CITY OF PORTLAND

August 6, 1999

It was recently noted that your swimming pool was not installed in accordance with Section 421.0 of the 1996 BOCA Code as stipulated in your permit issued June 29, 1999.

ROUND POOL SIZES

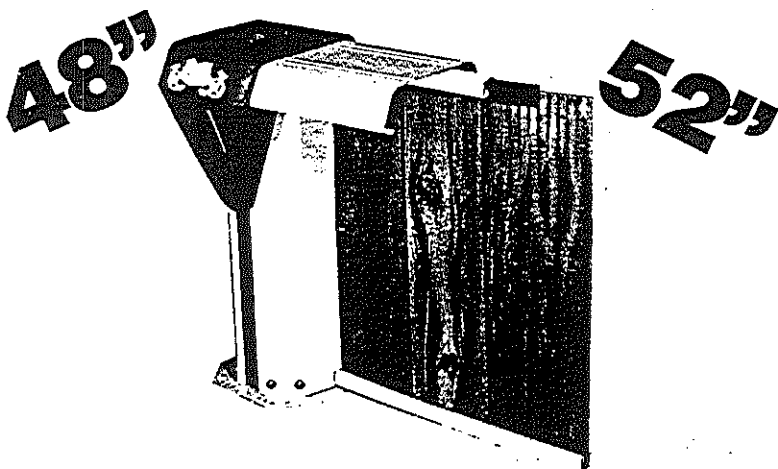
1. No ladder protection
